Development Facilitation Team (DHO) – Review Comments

Project No: PR-2018-001579 **Date:** 7/30/2025 **Agenda Item:** #1 **Zone Atlas Page:** J-18, J-19

Request: Major Preliminary Plat review

Application For: MAJOR PLT-2025-00009 – MAJOR PRELIMINARY PLAT

PROJECT  
LOCATION

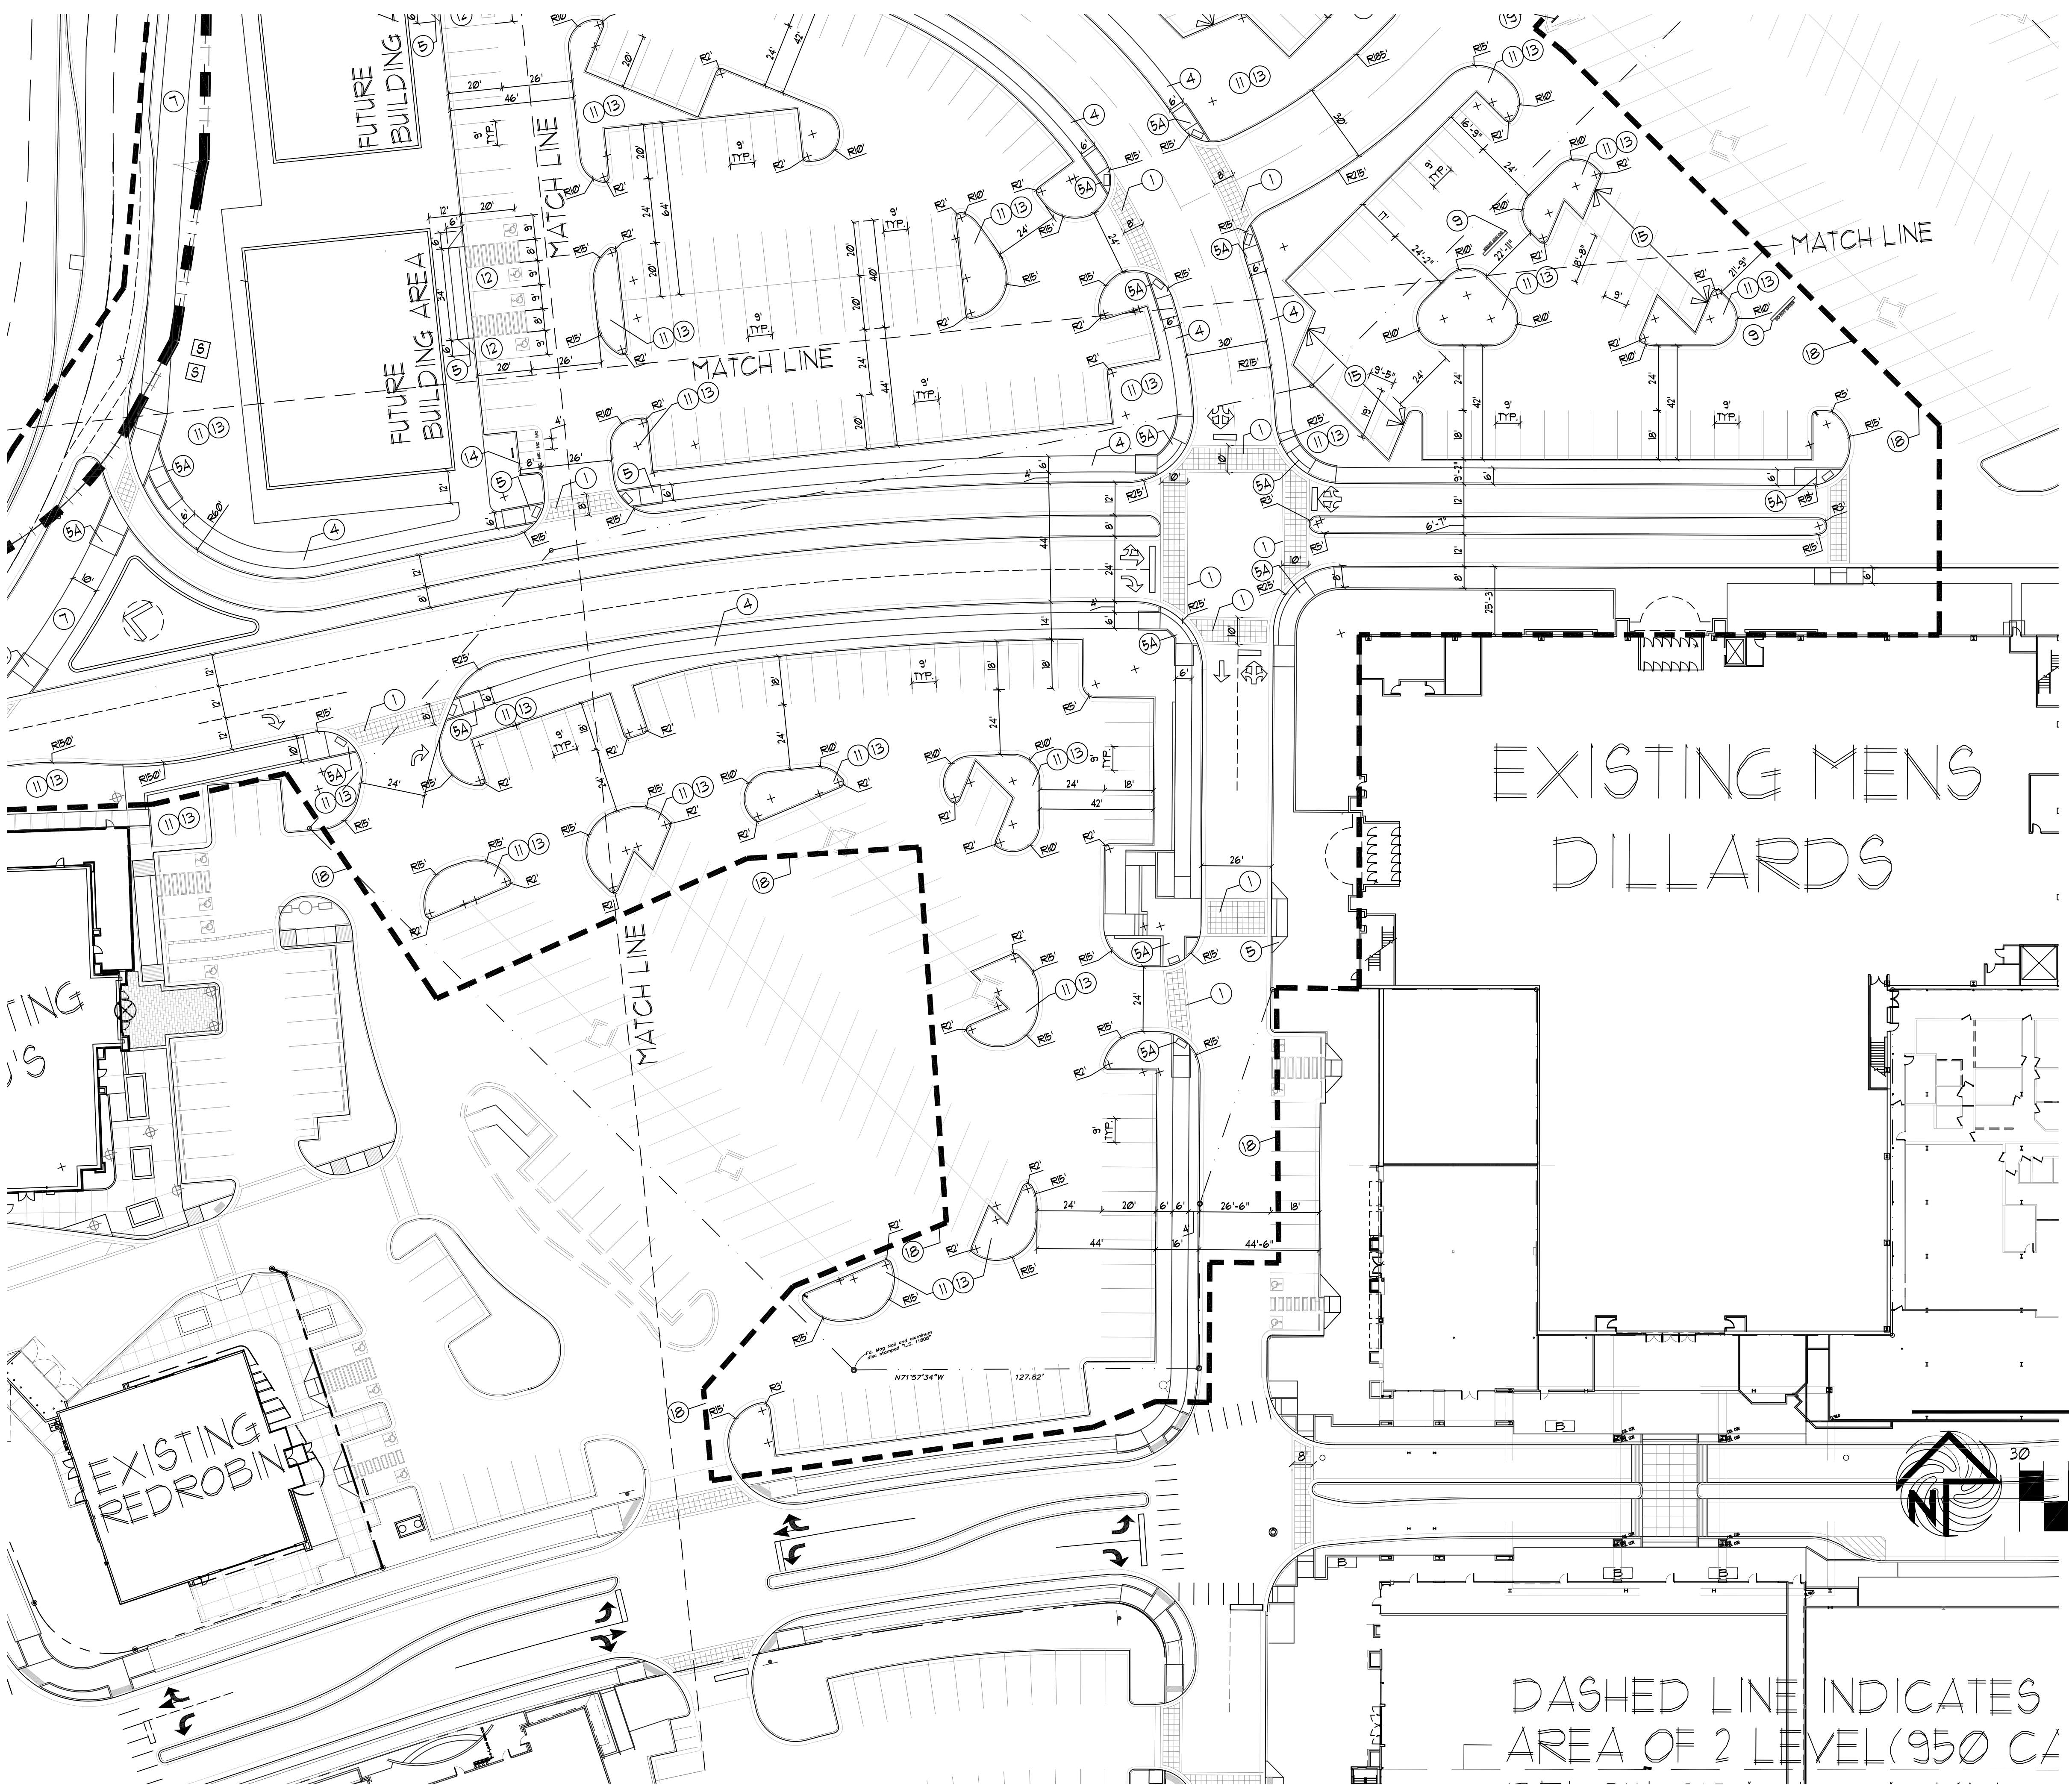
1. Your sidewalk exhibit only shows sidewalk interior to the site, but does not show widths on sidewalks along Louisiana or Indian School. Both are arterials within a center and require 10' sidewalks with 6' to 8' landscape buffers. Please show these widths to determine if widening is required.
